Design Note

Project Begbroke Innovation District
 Subject EA Responses to Flood Risk Comments
 Project no 052188
 Date 21 June 2024

Revision	Description	Issued by	Date	Approved (signature)
00	Initial Draft EA Response to Objection 02 on the basis of Flood Risk	GJ	21/06/2024

Figure 6.5: Difference in flood level between the baseline model and the North-west mitigation scenario in the 1% AEP event plus 41% allowance for climate change, 11 hour storm duration

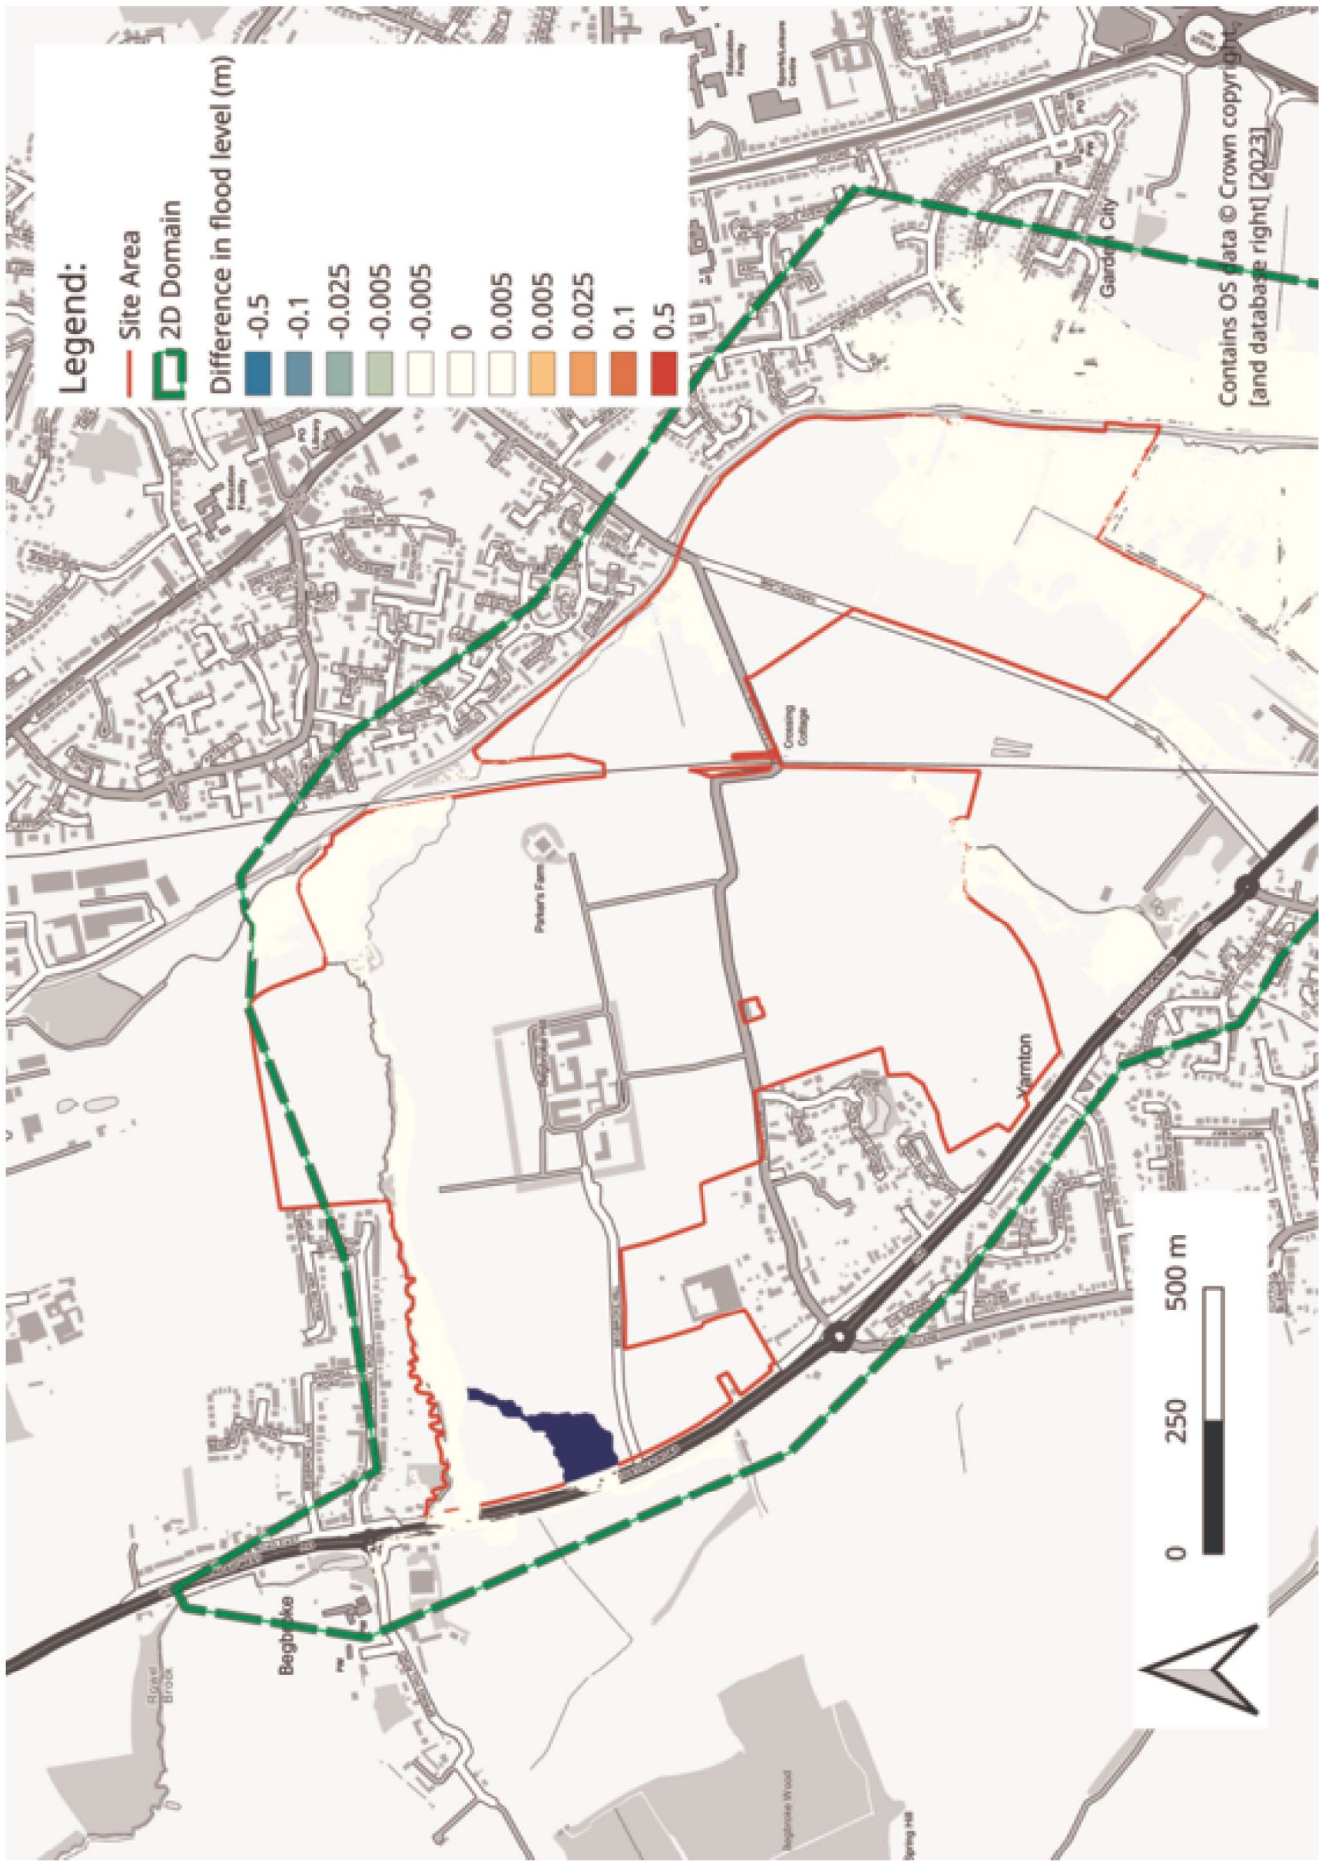
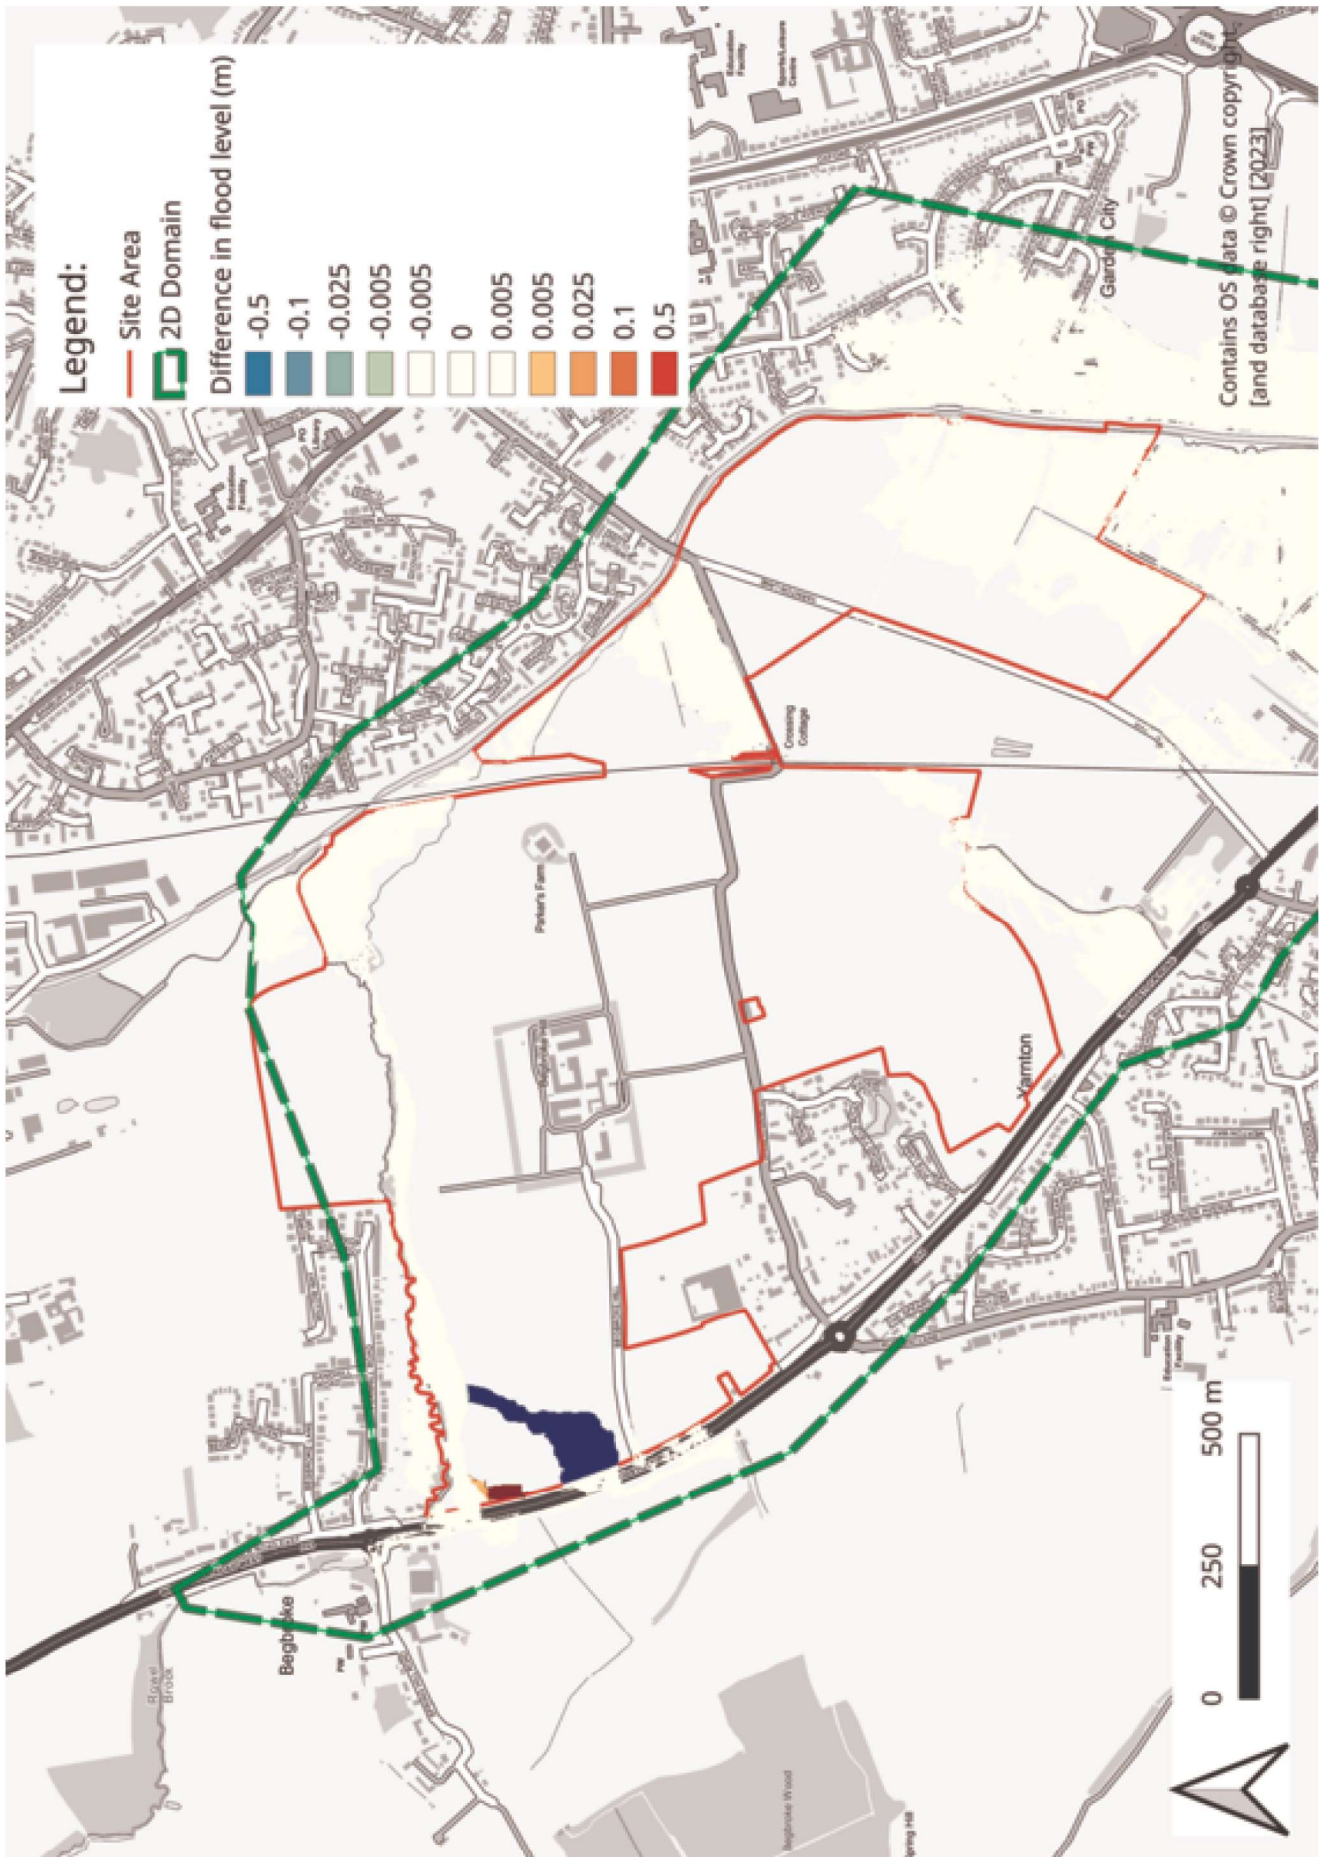
Item no.	Objection's/Comments	Responses and rectifications
6.2	<p>Instead, the applicant proposed a swale and ground level changes. Whilst we are now satisfied that the swale has now been appropriately modelled and detailed in model report, the impacts on flood risk are not clear from the submitted plans. We strongly recommend that an additional plan is provided to show the difference in modelled flood depths and extents, as well as the location and design of the proposed swale.</p>	<p>The design of the swale was outlined in the original FRA. Please refer to the difference plots presenting difference in modelled flood depths and extents which are shown in Figure 6.5 and 6.6 of the updated Hydraulic Modelling Report.</p>

6.3	<p>Further, modelling alone should not be used to show that flood risk would not increase elsewhere as small changes in flood risk may not be visible in the modelling.</p>	<p>Not agreed. Hydraulic modelling is used as a key indicator in the evaluation of the change in flood risk as a result of development. If the EA require modelling to evaluate and quantify the change in flood risk, then it is appropriate for applicants to use hydraulic modelling to demonstrate that the change is negligible.</p> <p>Hydraulic modelling of this mitigation measure demonstrates the impact on flood risk, as illustrated in the difference plots presenting difference in modelled flood depths and extents shown in Figure 6.5 and 6.6 of the updated Hydraulic Modelling Report.</p>
